10 October 2018

Our Ref: 2018/516796

Re. Modification 1 to concept approval for UTS Blackfriars Precinct Research Building, Chippendale (SSD 6746)

Drawing Title  
**UTS BLACKFRIARS CAMPUS CB23**  
**A02 - PROPOSED BUILDING ENVELOPE PLAN**

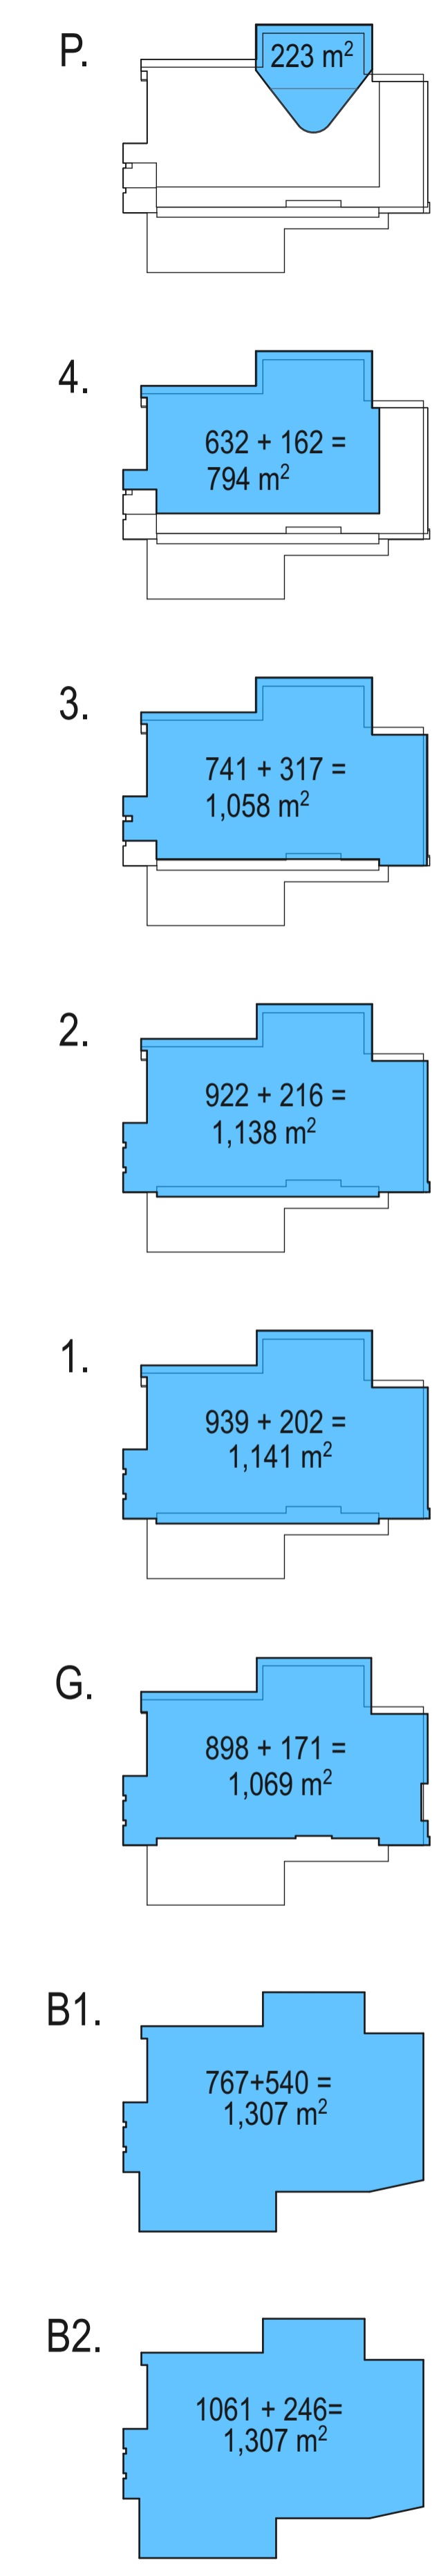
- a) Condition A7 (a) specifically requires that the existing heritage palisade fence is retained in its entirety. The proposal seeks to completely remove and replace the heritage significant fence however, no explanation has been provided as to how the fence will be reused and where. While more detailed information is usually provided at Stage 2, it's in principle removal is being sought as part of this Stage 1 modification and consequently, adequate justification is required at this stage. At a minimum, if the Department are minded to approve its removal, the fence must be carefully salvaged and reconstructed in its original position and detail.

- c) Consent condition A7 (b) requires a setback of 9.29m or the distance required to retain trees T33 and T34. The proposed modification removes both T33 and T34, and seeks to reduce the setback to a minimum of 3.7m.

It is noted that the reduced dimension is not accurate. There are retaining walls proposed within the 3700mm zone that create a sunken garden 5.94m below street level and “light wells” to the basement levels (see below – red line).

**PROPOSED ENVELOPE SECTION-LOOKING NORTH 1:250 @A1**

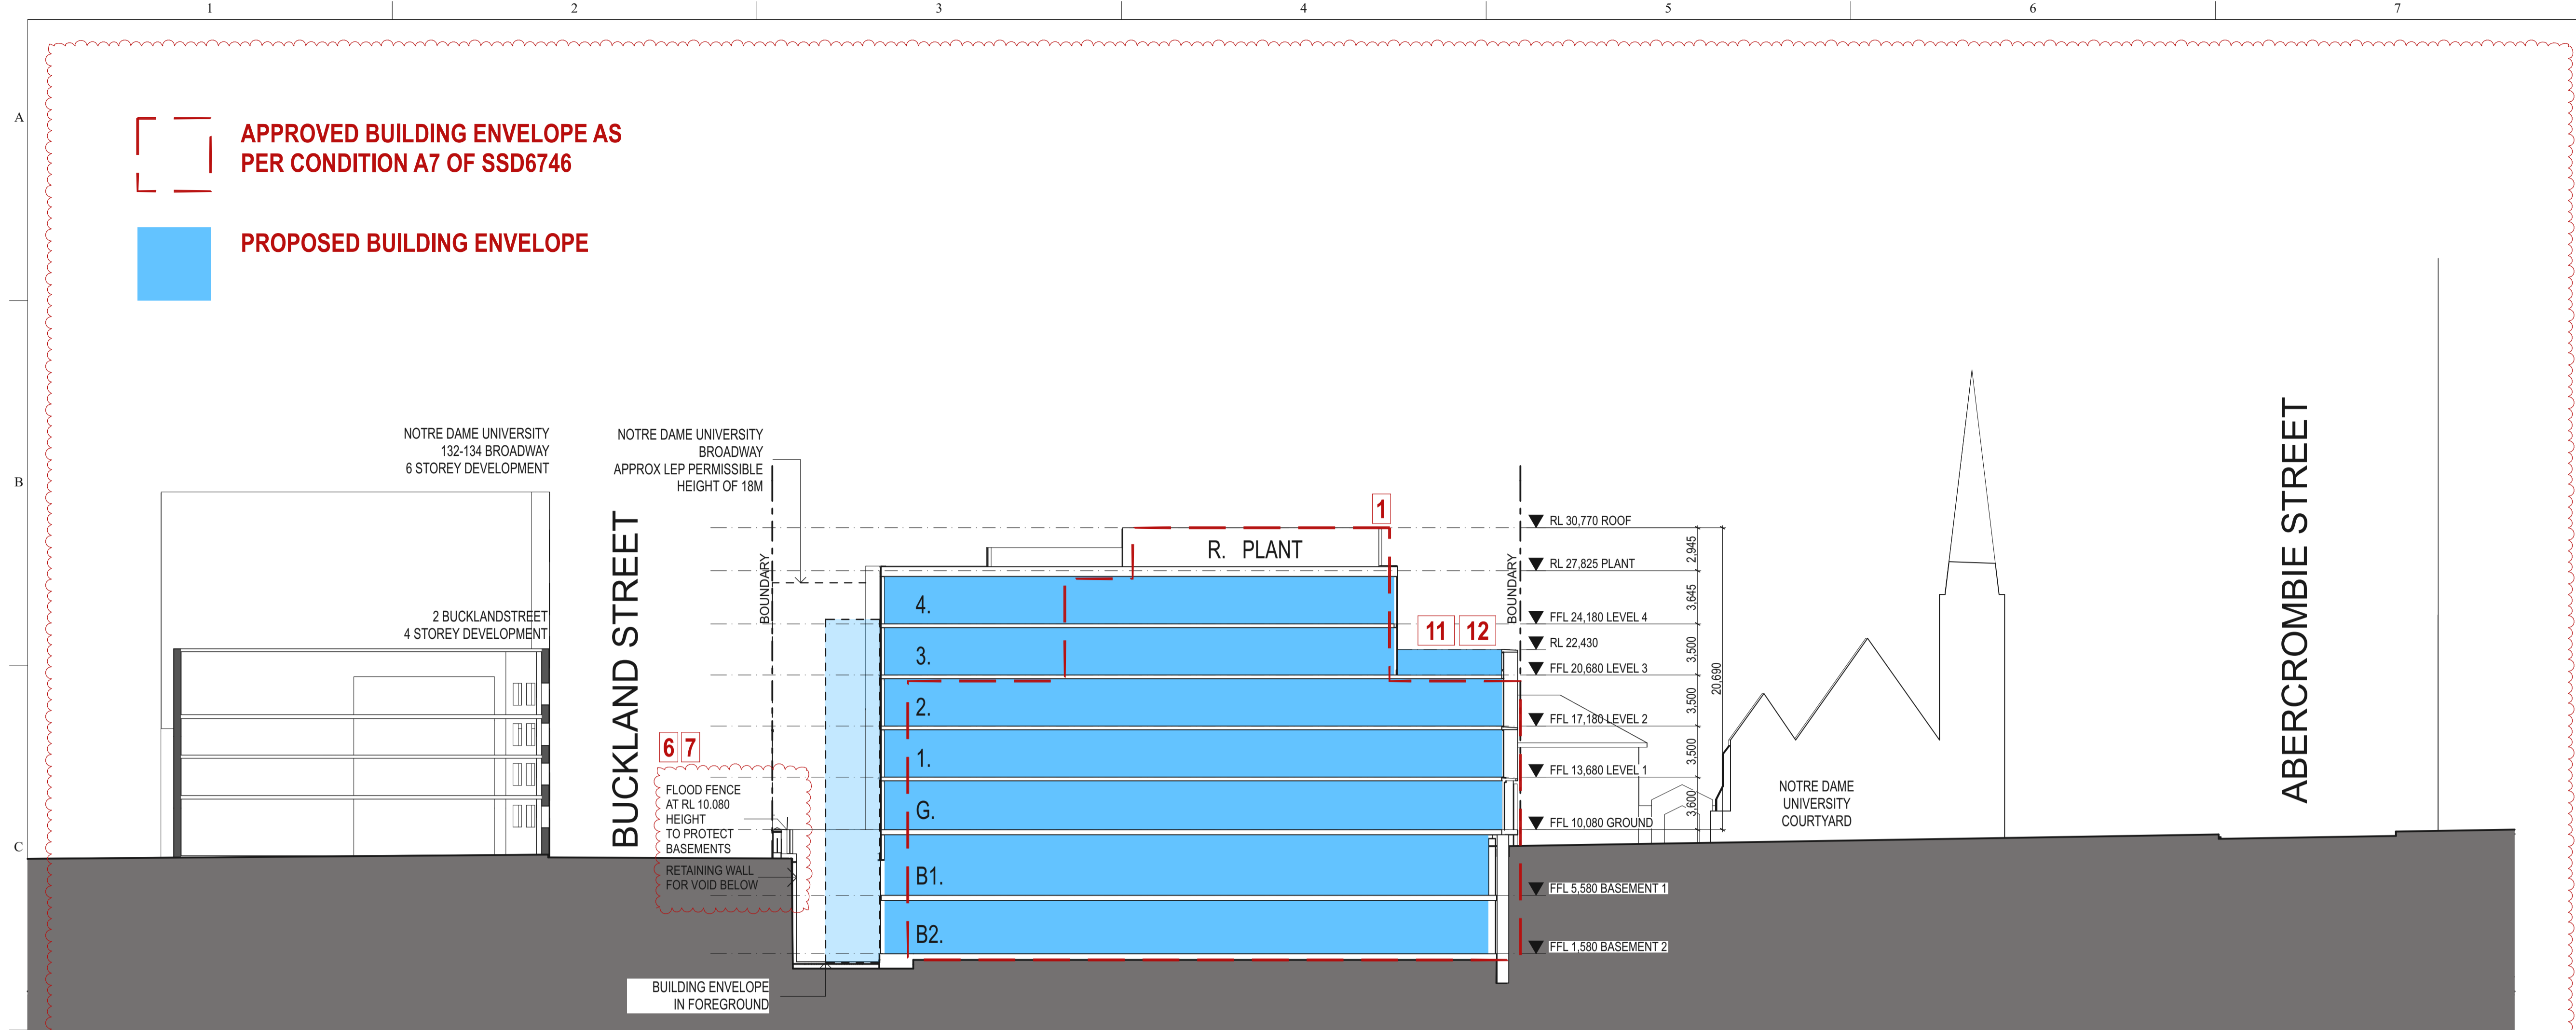
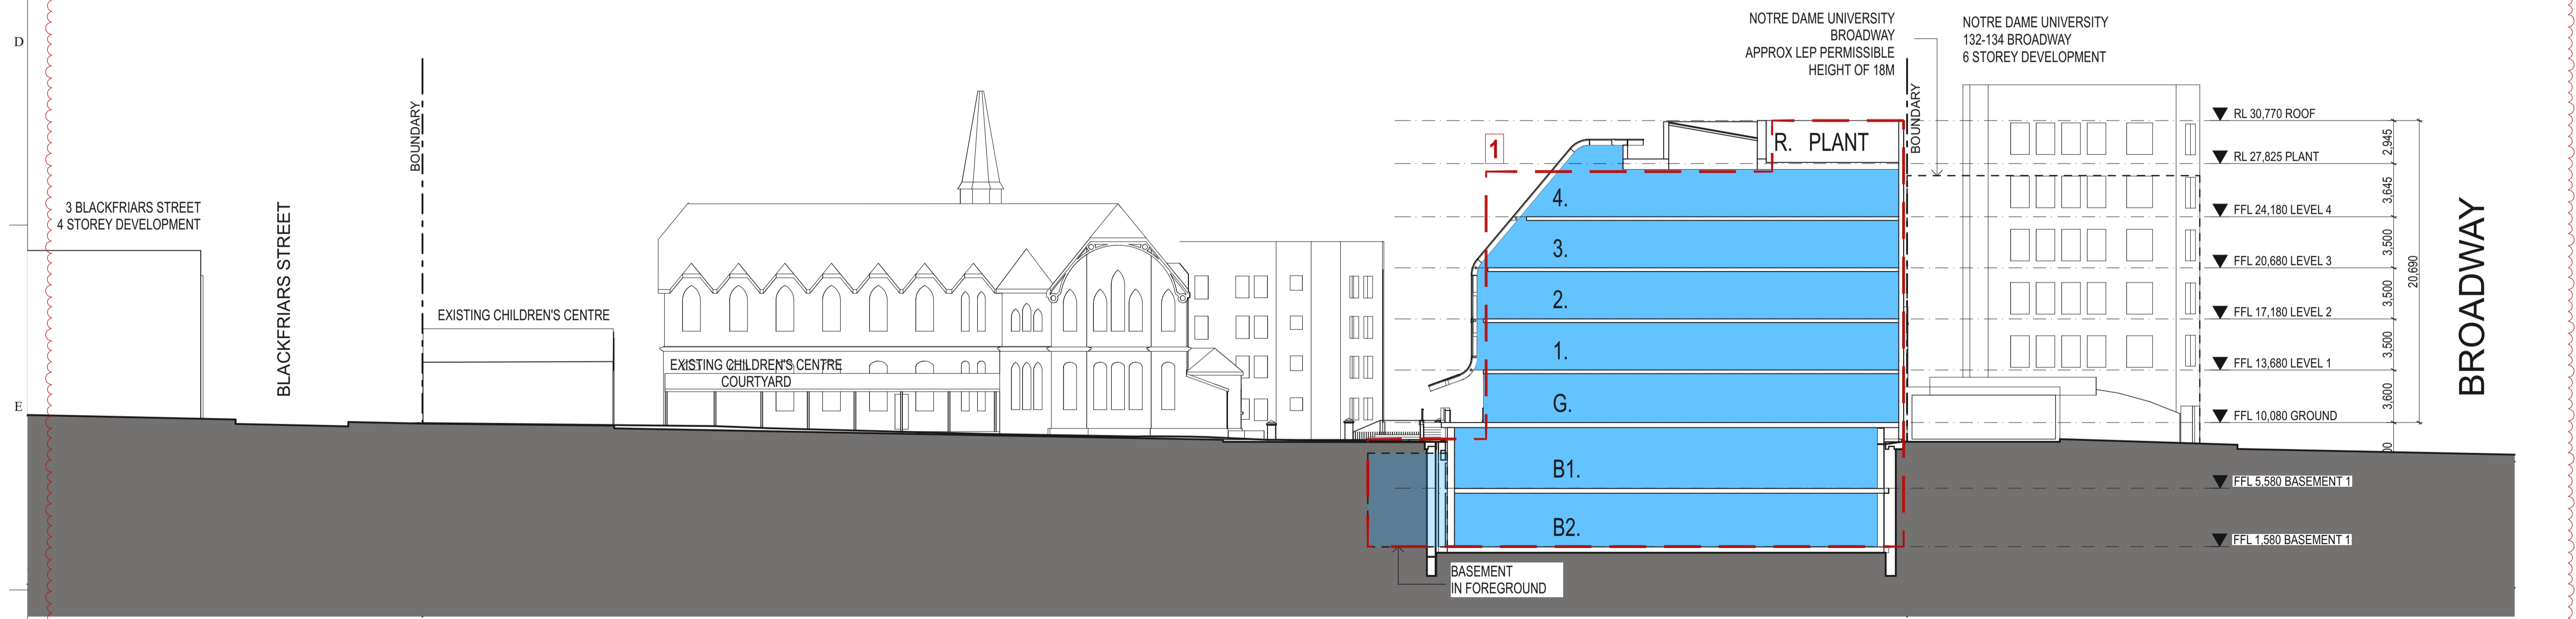
- e) The height of the proposed envelope is still considered too high along its eastern edge and will have a detrimental impact on the adjacent St Benedict's church and the courtyard of the Notre Dame campus immediately south of St Benedict's Church. Stepping back the eastern elevation would assist to address this issue.

This view is reflected in the Department's assessment report for the approved concept application (page 28) that *"an 18m height adjacent to the permitted 18 metre height zone along Broadway would be acceptable with the exception of where the building is adjacent to the church, or existing courtyards or open space a height limit of nine metres is appropriate"*. Consent condition A7 (c) requires a maximum RL of 20.27. The modified envelope diagrams show a height of 11m (RL 21.68 or higher) adjacent to the Notre Dame courtyard.

Drawing Title UTS BLACKFRIARS CAMPUS CB23 A09 - ST BENEDICT'S COURTYARD SHADOW STUDY		
FMU Project Number 03013-C-18		
Drawn By SB, JH, JB, KP	Checked RS, KL	Approved By TG

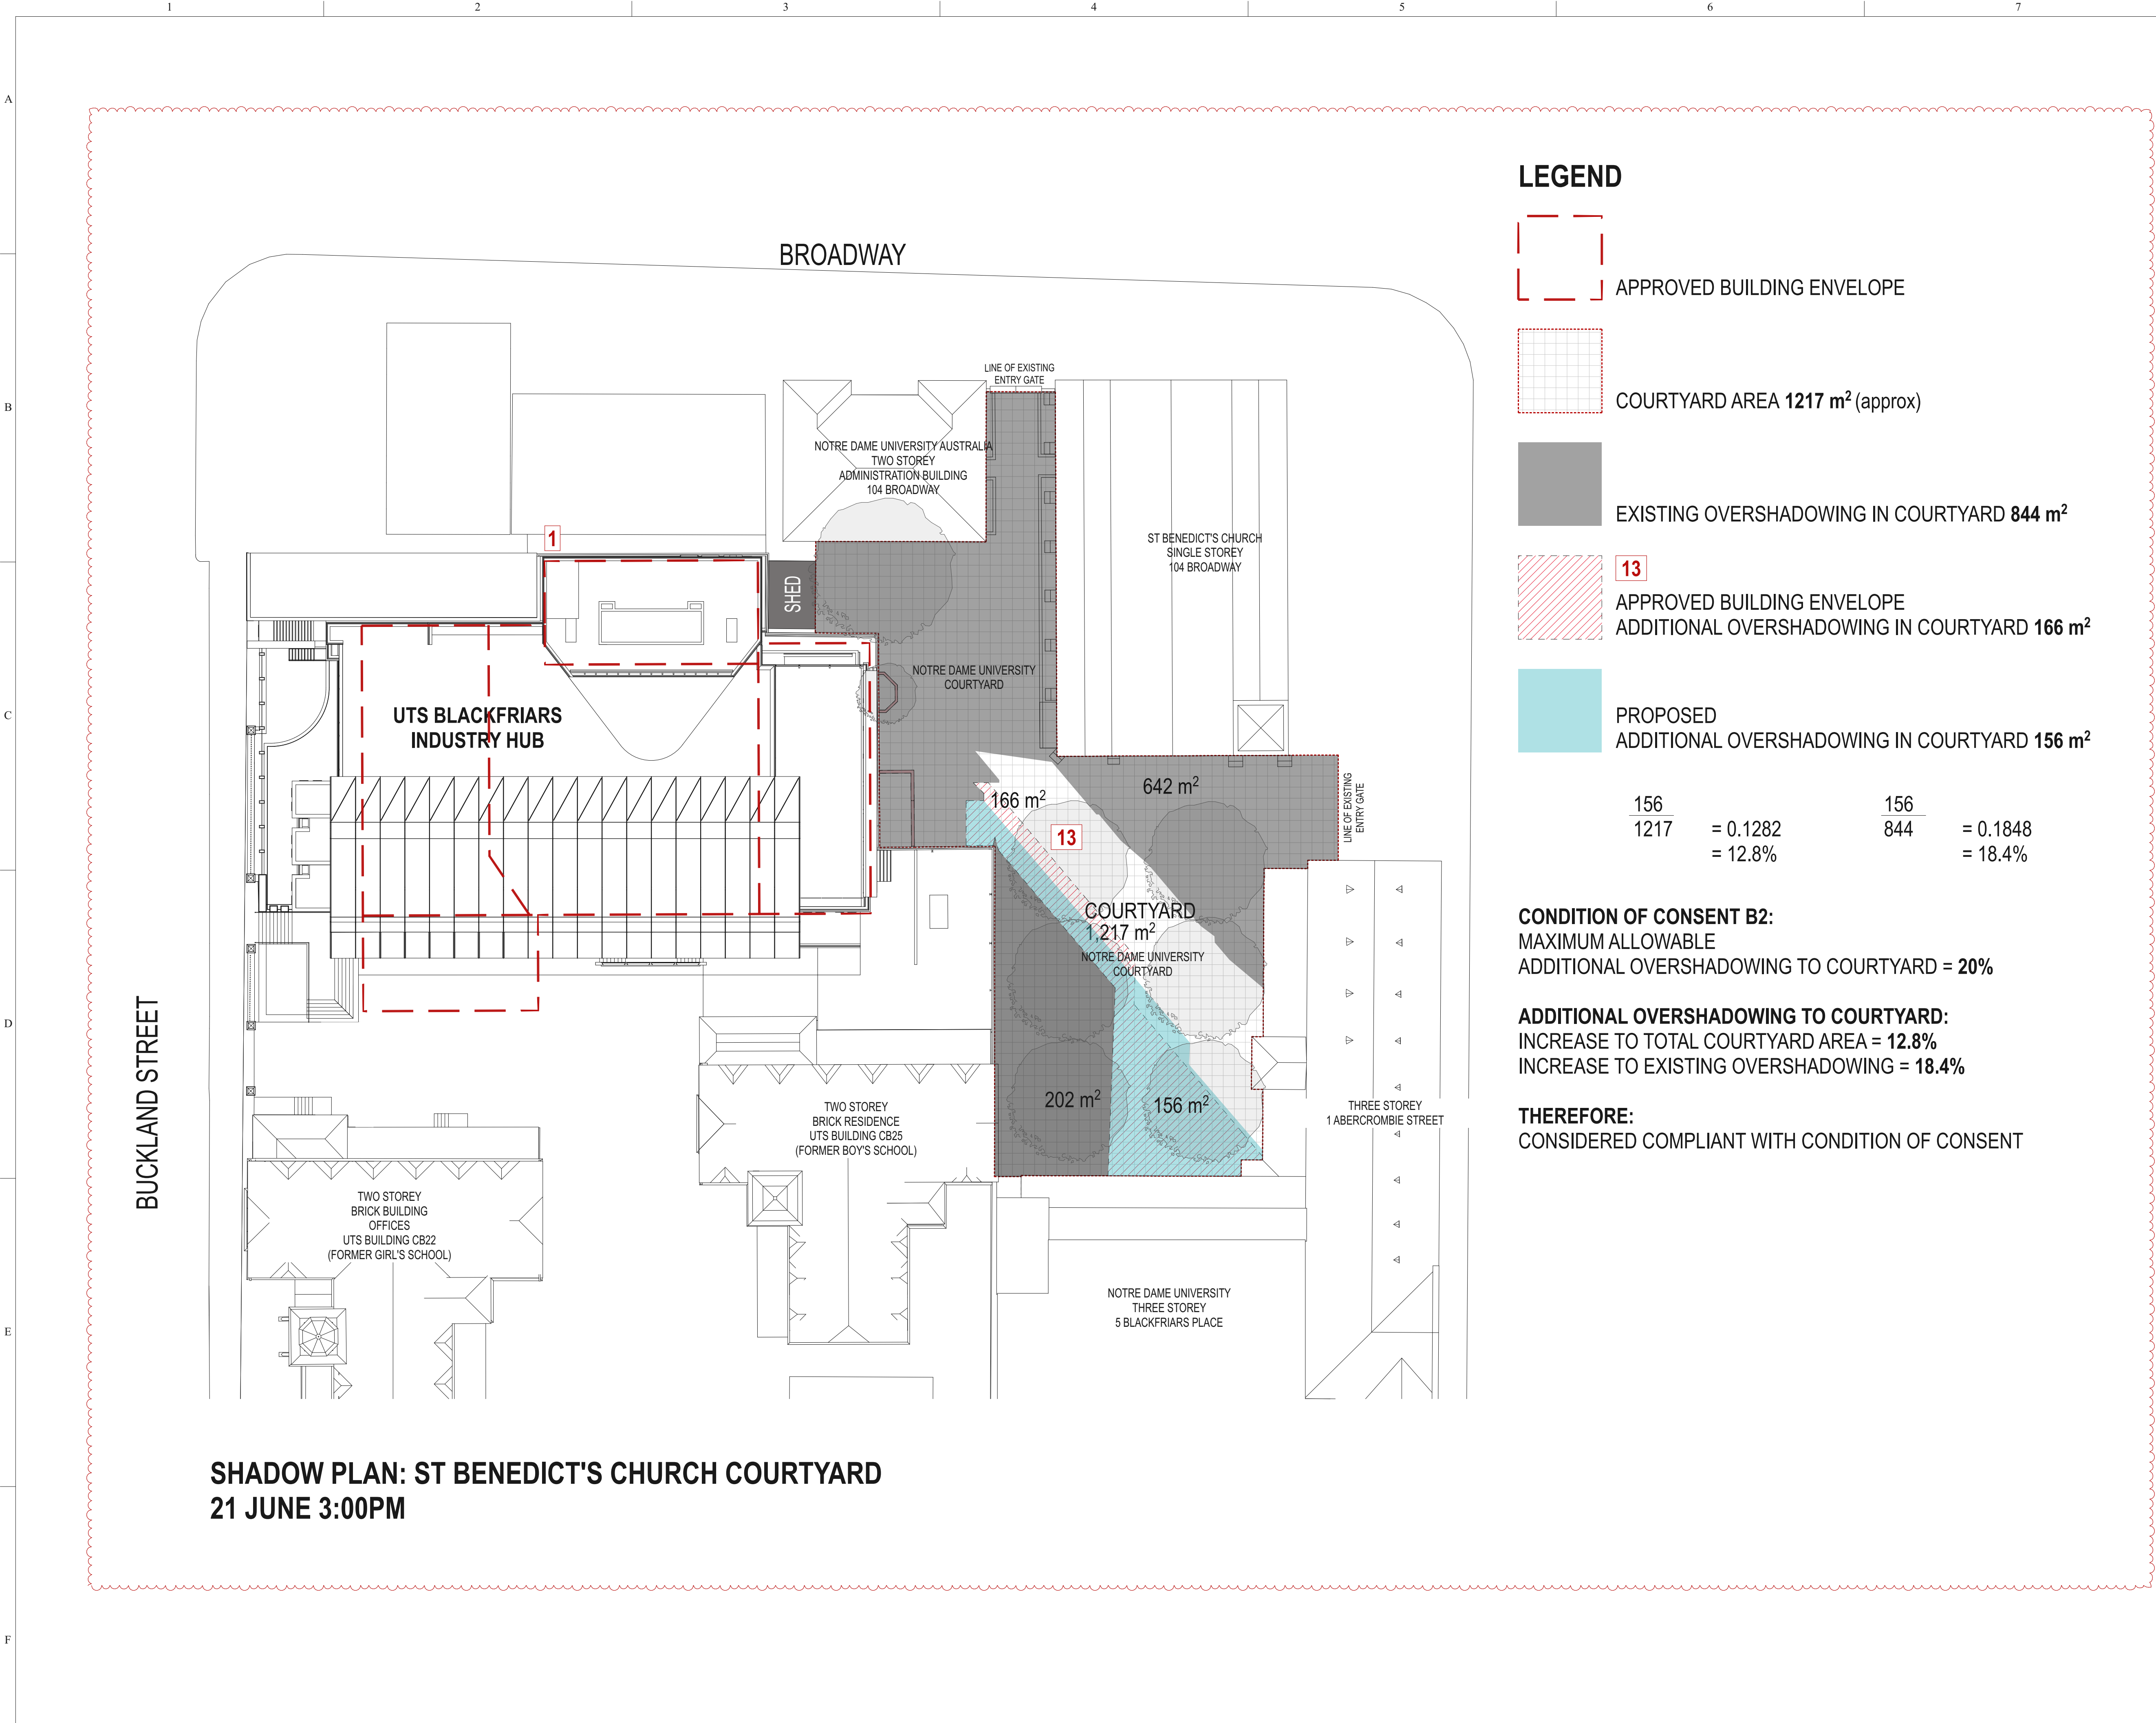
Further, while technically compliant with Condition B2, the 3pm shadow diagram demonstrates that the courtyard will be 82% in shadow and is considered a very poor amenity outcome. The effect of reducing height in accordance with condition A7 (c) at this location on overshadowing to the courtyard should be tested.
